Online Comment

Application H09-0378-25
Location No 1 West End Holbeach Spalding PE12 7LW
Proposal Change of use of first floor office to 2 bedroom apartment including alterations & extension

Name Greg Watkinson
Address Conservation Officer

Date Submitted 23-05-25
For/Against Comments

Drawing
 FLOOR PLANS - PROPOSED
 ELEVATIONS - PROPOSED

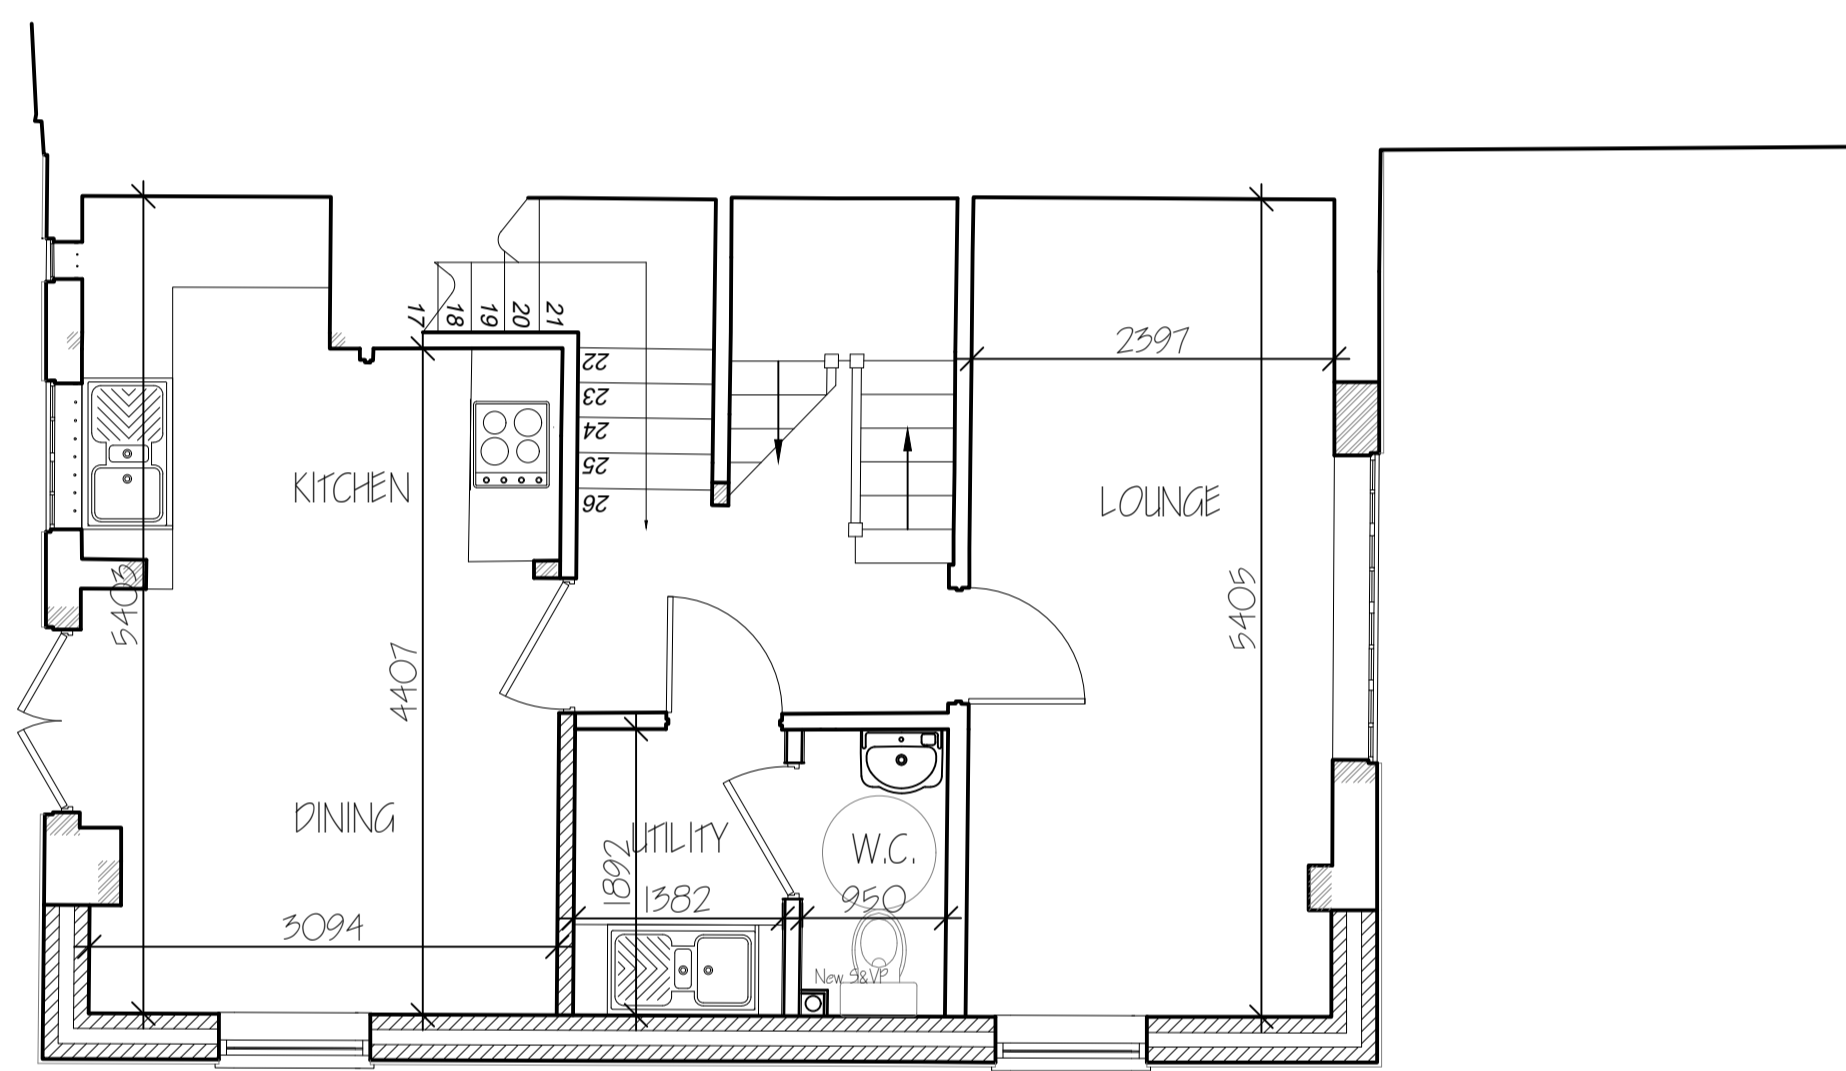
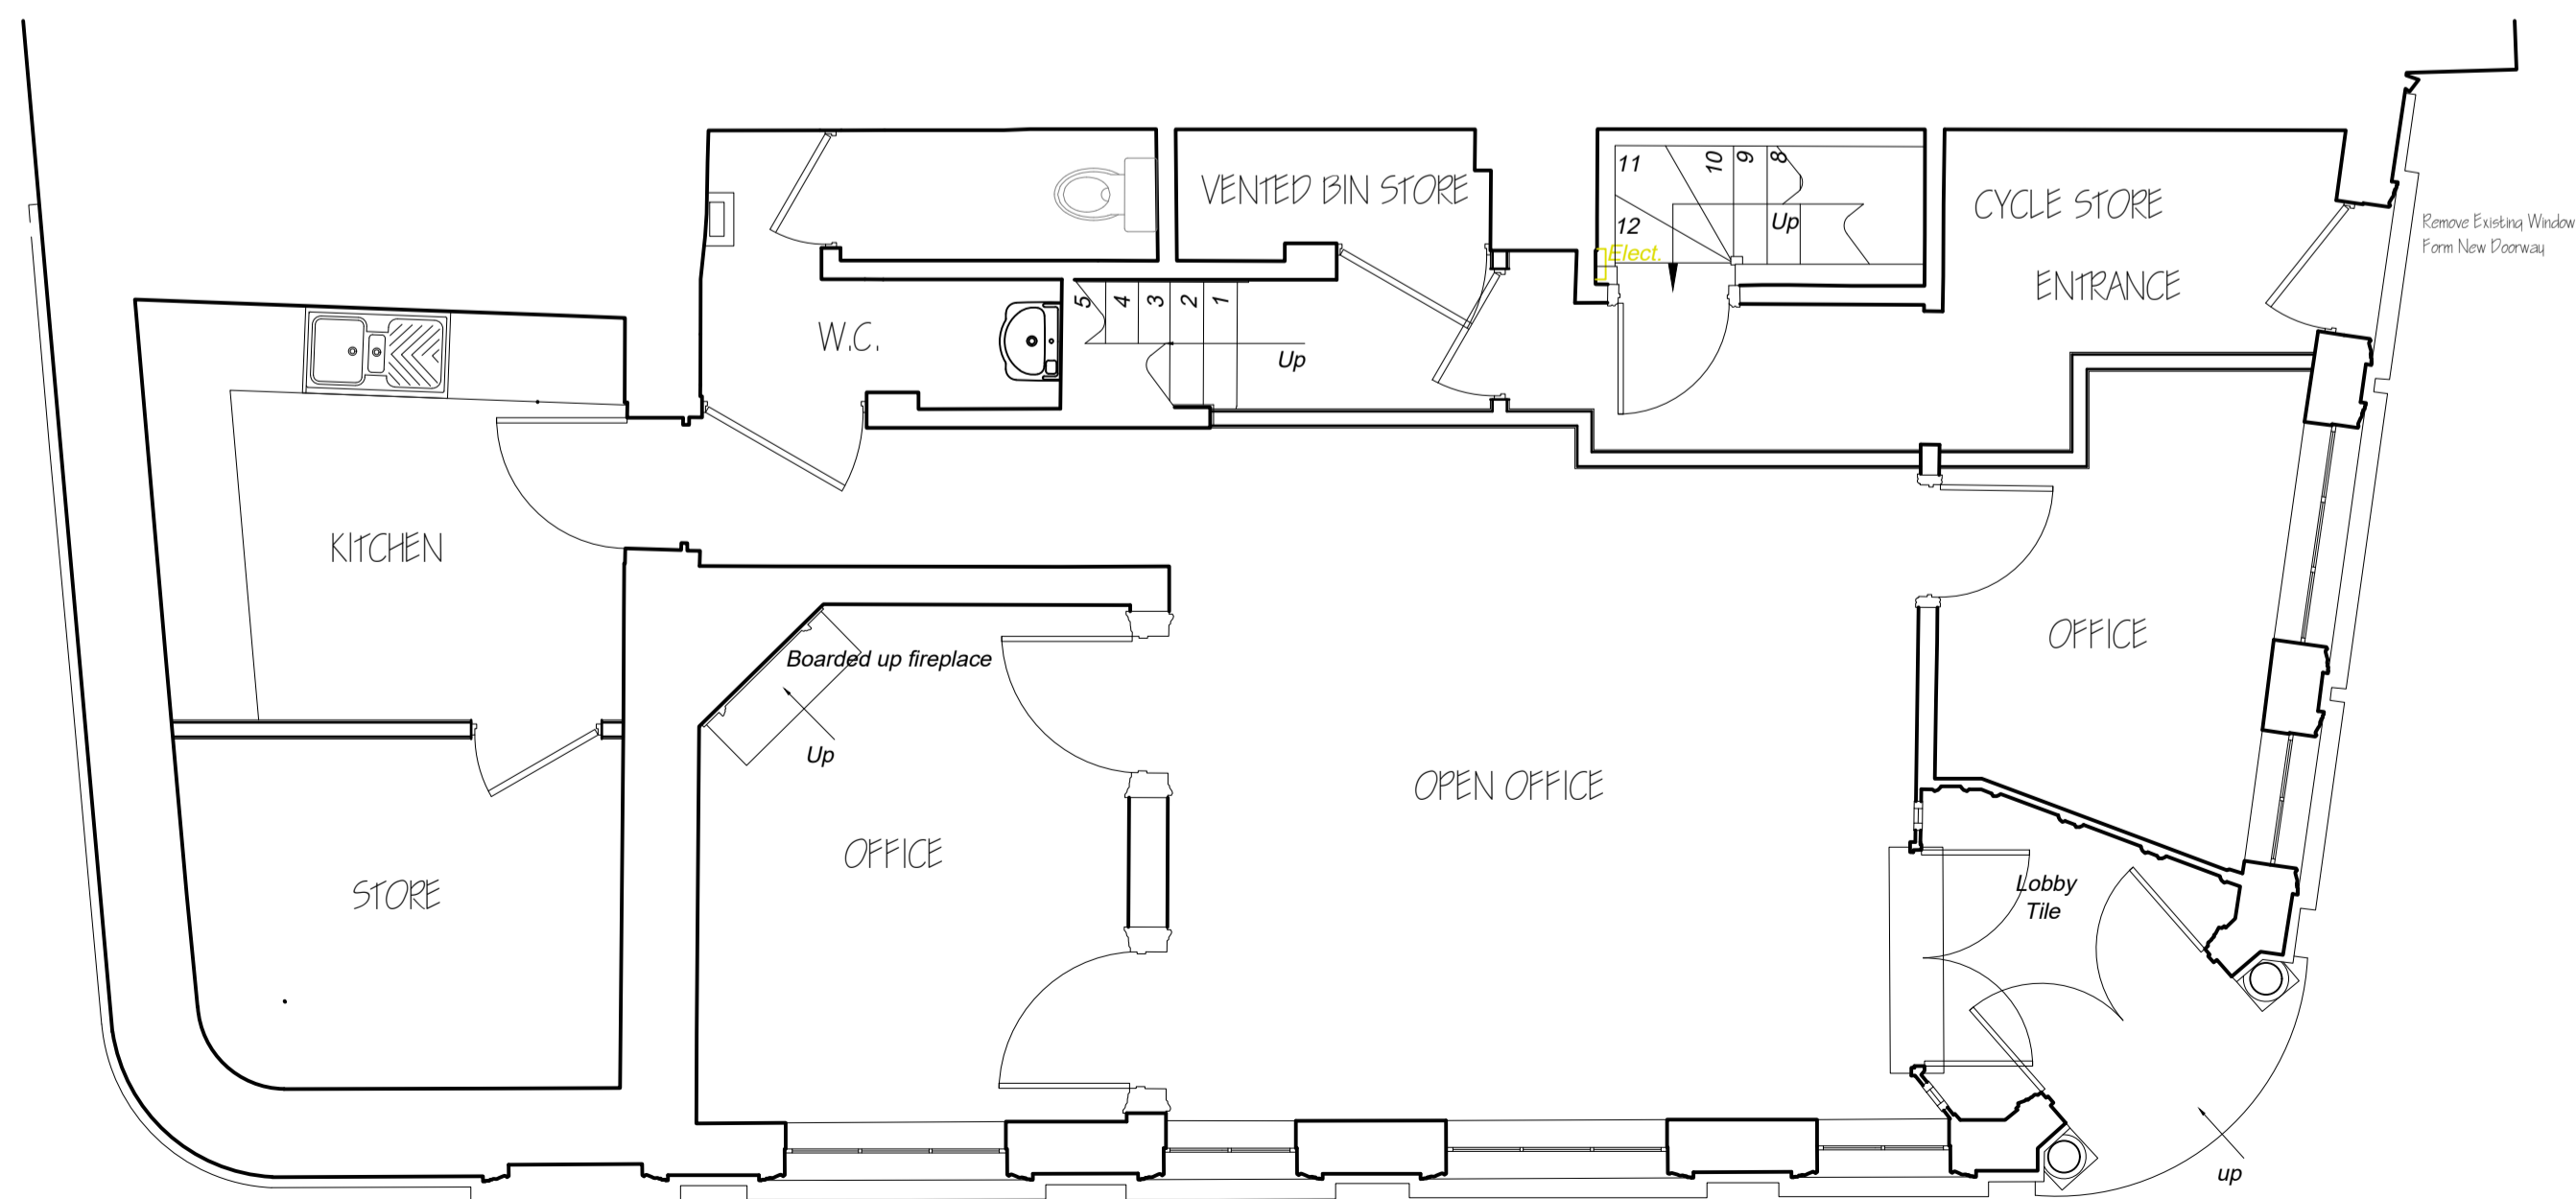
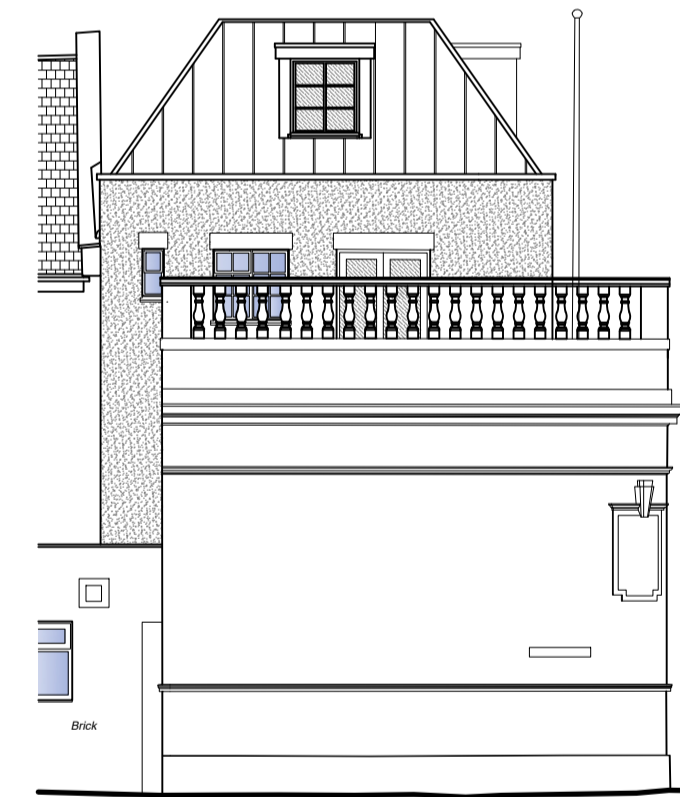
On the one hand, were the above-ground-floor aspects of this proposal to be an entirely new structure/extension being proposed, there would be obvious reasons to object to the proposal given the relatively unattractive and obtrusive nature of the structure above the ground-floor level. The submitted Heritage Impact Assessment acknowledges the inappropriate nature of the extant roof extension.

However, this is a proposal simply to alter and adapt an existing somewhat inappropriate flat-roofed rooftop extension by adding a metal standing seam roof, allowing for the use of the eaves space. Therefore, this can - as mentioned in the HIA - be considered to be an exercise in improving an existing feature by means of enhanced detailing and more sympathetic treatment.

In this regard, proposals to add new stone balustrading can be considered a great enhancement to the character of the original structure, whilst also working to add a visual barrier to some of the rooftop structures.

I therefore wish to raise no objection to the proposal. However, given the extreme prominence of this building and its value to the character of the conservation area, I recommend that should the application be approved, conditions requiring a materials schedule, as well as specific detailing of all windows and doors and the design of the additional balustrading shall be submitted to and approved in writing by the LPA. As acknowledged in the HIA, the acceptability of this proposal fundamentally pivots upon the quality of the fine detail and therefore, it shall be a basic expectation that the absolute highest possible quality of design and materials shall be employed to satisfy these conditions.
